RE: NEWCASTLE GAS STORAGE FACILITY (10-0133)

I refer to your request for Hunter Water's comments regarding the Environmental Assessment Report for the development of a Gas Storage Facility at Tomago. Hunter Water understands that the applicant proposes to develop a 28ha site, which will include clearing of approximately 14ha of vegetation and construction of a gas liquefaction complex.

Review of AGL Gas Liquefaction Plant Environmental Assessment (EA)

Figure 4: Gas Plant Site Layout

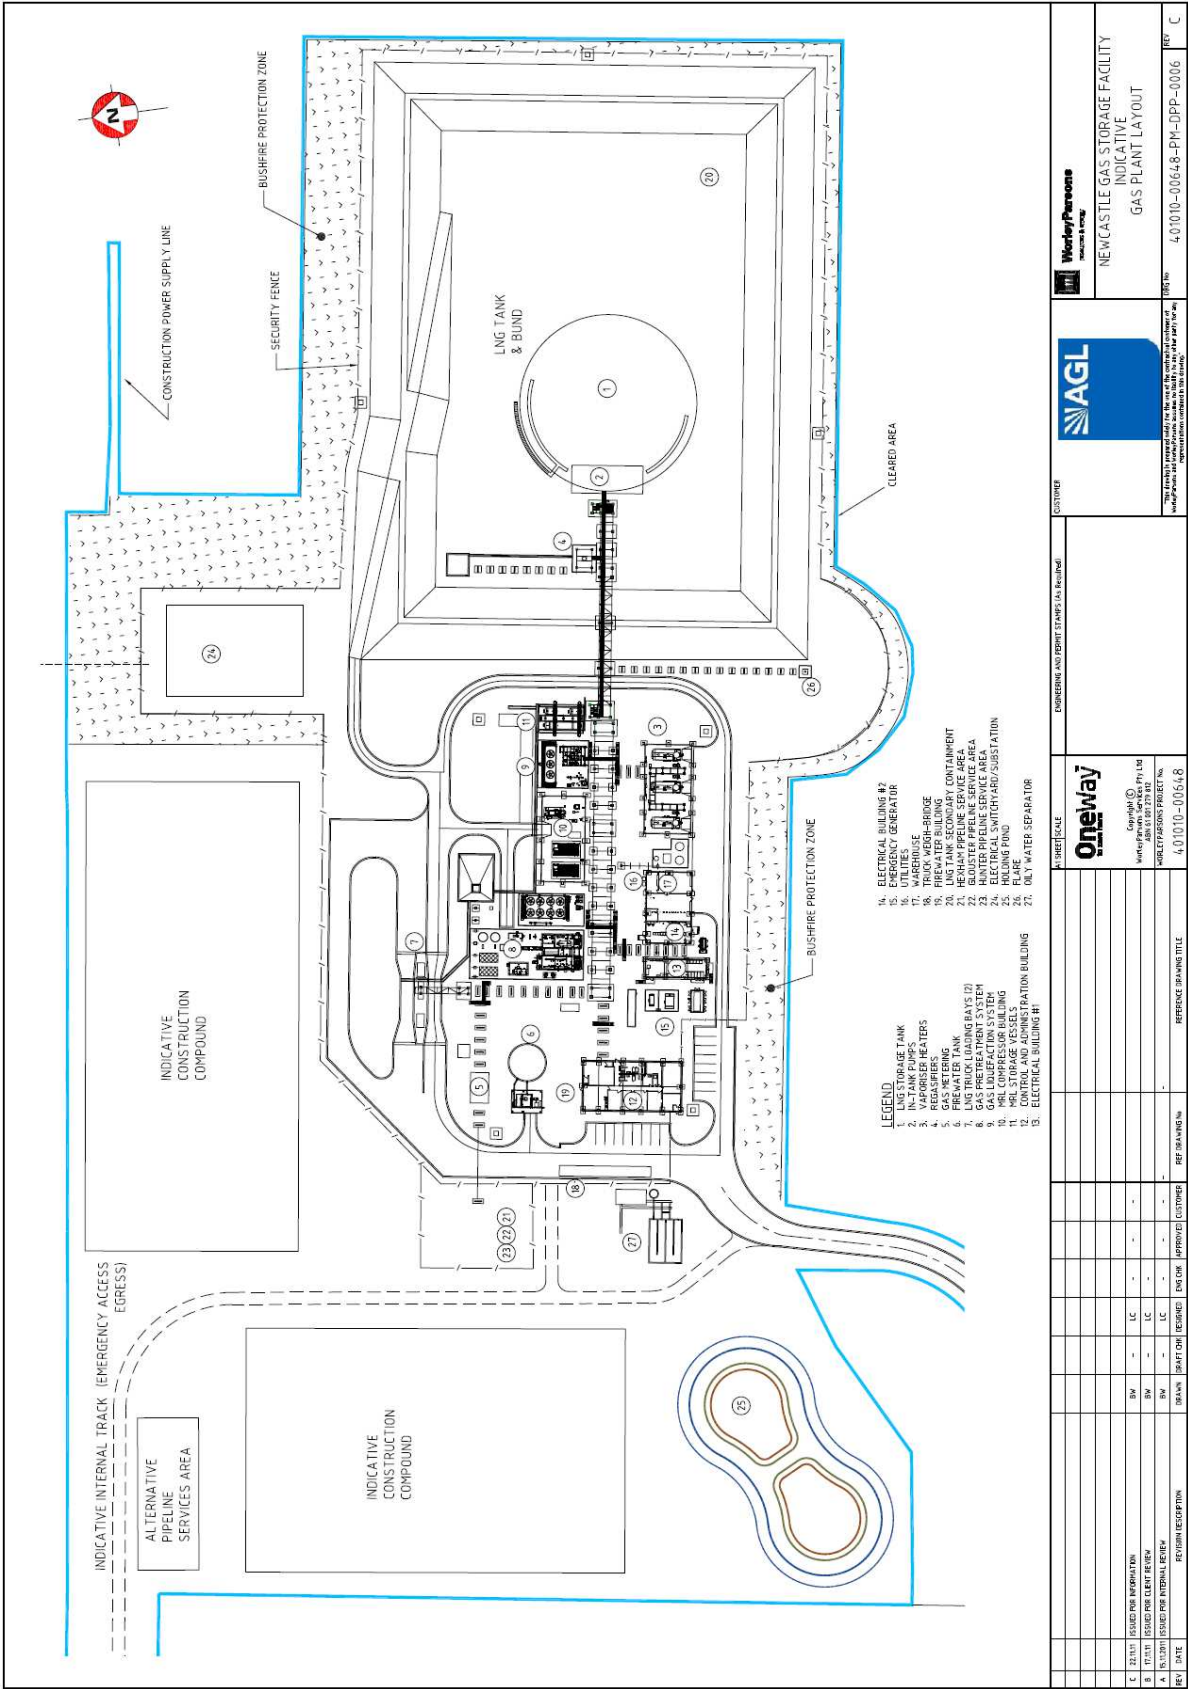
Hunter Water has reviewed the stormwater management plan that is contained in the EA and as modified in the correspondence attached in Appendix A to this submission. The proposed strategy has been designed to provide separation of stormwater that is generated off roadways within the fenced area of the site, the uncovered plant areas, and the general plant areas from the aquifer beneath the site. Stormwater will be collected in a holding pond, and then discharged off the site into a creek line that flows west towards the Hunter River. The system is designed for up to a 1 in 100 year ARI rain event. It is extremely important that the detail design, selected materials and workmanship are of a sufficient standard to ensure that the proposed system will be built water-tight and have a design life that is commensurate with the design life of the facility as a whole.

Within the fenced complex, the proposed strategy will not catch stormwater from non-plant areas, and will not catch stormwater from the LNG tank bunded area. While it is not inconceivable that pollution could enter the aquifer from these areas, the risk of pollution from these areas is low and can be managed. It is proposed in the EA, in Chapter 4.2, that access to the site will require entry through a security gatehouse and that the site will be manned and monitored by security personnel 24/7. Such security will substantially mitigate the risk of unauthorised activities occurring on the site that may pose a risk to the aquifer. With regard to the bunded tank area, LNG itself, while being a highly hazardous material from many perspectives, cannot cause pollution of the groundwater beneath the site. In order to perform its required purpose, the bunded tank area will effectively be sterilised from other activities apart from site maintenance.

The proposed stormwater management strategy does not extend outside the fenced complex. Arguably the greatest risk to the aquifer in these areas would be third party illegal dumping of toxic materials, which would be possible in the cleared area surrounding the security fence, along the utility corridor, and especially along the main access road. Hunter Water is of the opinion that this risk has not yet been adequately addressed.

1. The stormwater management plan that is presented in concept in Appendix A of this submission must be designed and built to be robust and long lasting. In order to ensure that these objectives are met, Hunter Water requires that conditions be placed on the developer to:

- a. Provide Hunter Water Corporation with a peer review of the detail design of the stormwater management system by a mutually agreed third party, to be funded by the proponent. The peer review shall investigate the durability, effectiveness and constructability of the stormwater management system. Elements of the design that are found lacking in quality by the peer review shall be addressed by the proponent and re-reviewed at their cost. Once an adequate design has been agreed upon, the peer reviewer shall nominate an inspection schedule, in consultation with Hunter Water Corporation, to be undertaken during construction to ensure that the system is constructed as designed.

5. The proponent shall develop a strategy to minimise the chance of illegal dumping of materials along the main access road, along the utilities corridor, and outside the fenced compound. Strategies could include, for example, line-of-sight view of the access road from the gatehouse, motion detectors at the western end of the access road to alert security staff when a vehicle is approaching, signage or CCTV systems. Similar strategies may be possible for the utilities corridor, or it may be possible to gate that route to prevent unauthorised access. Access to the cleared area around the fenced compound may not be a problem if the measures introduced for the main access road and utilities corridor are sufficient to keep unauthorised persons away from the site in general.

Figure 9: Groundwater Flow

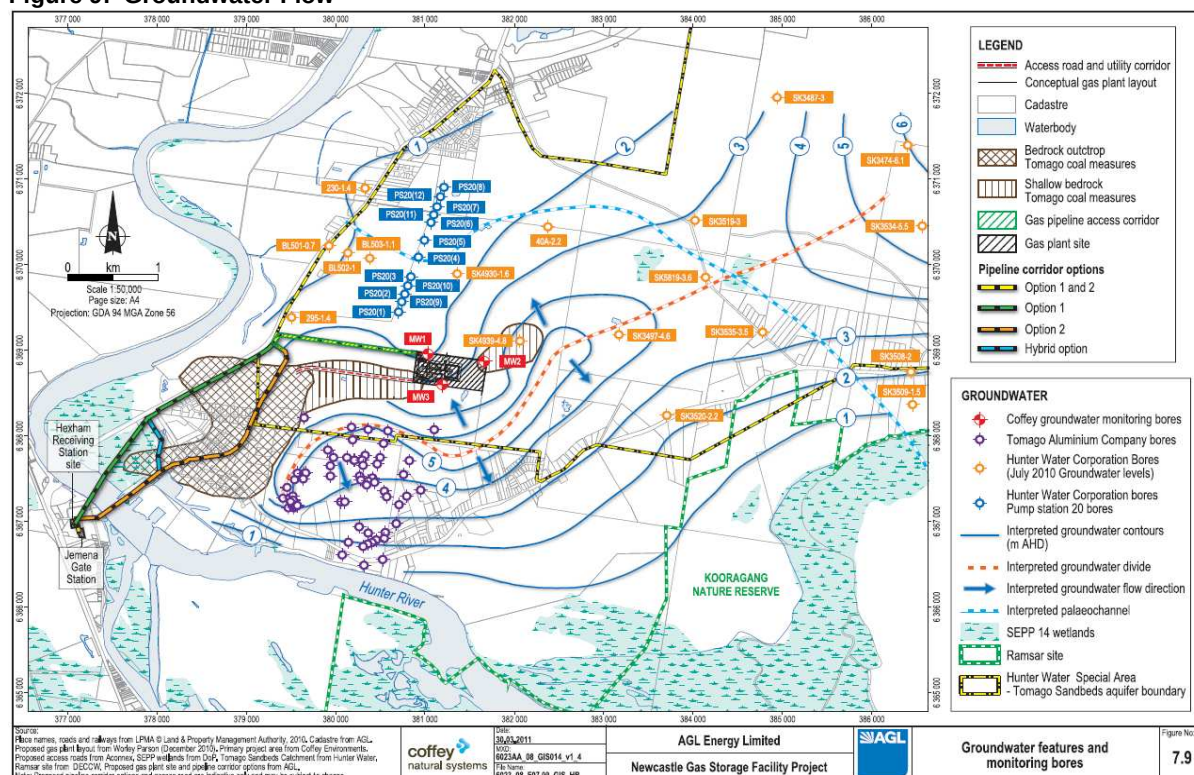
Extensive hydrogeological assessment has been undertaken and this work shows that any contamination that is introduced on the proposed site would migrate towards a Hunter Water boreline, Station 20. This analysis clearly establishes the need to design strategies to eliminate the risk of groundwater contamination reaching the boreline.

During review of the travel time assessment between the proposed facility and the nearest Hunter Water boreline, it has been noted that the analysis was done on the basis of the hydraulic conductivity being around 10m/day. The value of hydraulic conductivity used in the assessment is low compared with other estimates for the Tomago Sandbeds. It is understood that the value was obtained from on-site testing of permeability.

While there is no reason to doubt the veracity of the determination that the hydraulic conductivity is around 10m/day at the site, it would be risky to assume that it is this low all the way from the proposed facility to the nearest boreline. Generally a value of around 20m/day is assumed for the Tomago sands, though there are pump test results that indicate substantially higher values, and higher conductivities have been used in the past to achieve better calibration of hydrogeological models. It is also argued that actual hydraulic conductivity can be substantially higher due to real-life heterogeneity within an aquifer compared with the homogeneity assumptions (ie averaged values) used in aquifer characterisations. If the hydraulic conductivity is twice as high as modelled, for example, contaminant travel times would halve, and the contaminant would travel twice as far as predicted in any given timestep. It is quite conceivable that the travel time from the proposed facility to the Station 20 could be 5 years (or less) rather than the estimated 10 years.

2. The proponent shall review the proposed frequency of monitoring and other aspects of the proposed groundwater monitoring strategies to check that they are based on appropriate assumptions of hydraulic conductivity and catchment recharge. It is important that appropriate estimates of hydraulic conductivity and aquifer recharge have been used in relation to the risks being contained. Estimated recharge rates should take into account clearing of the site in question as well as neighbouring sites to the south (unless the land to the south is rezoned as conservation land). Assumptions regarding hydraulic conductivity shall be sensitivity tested regarding the potential for preferential flow paths and the likely range of hydraulic conductivity that may be encountered across the site.
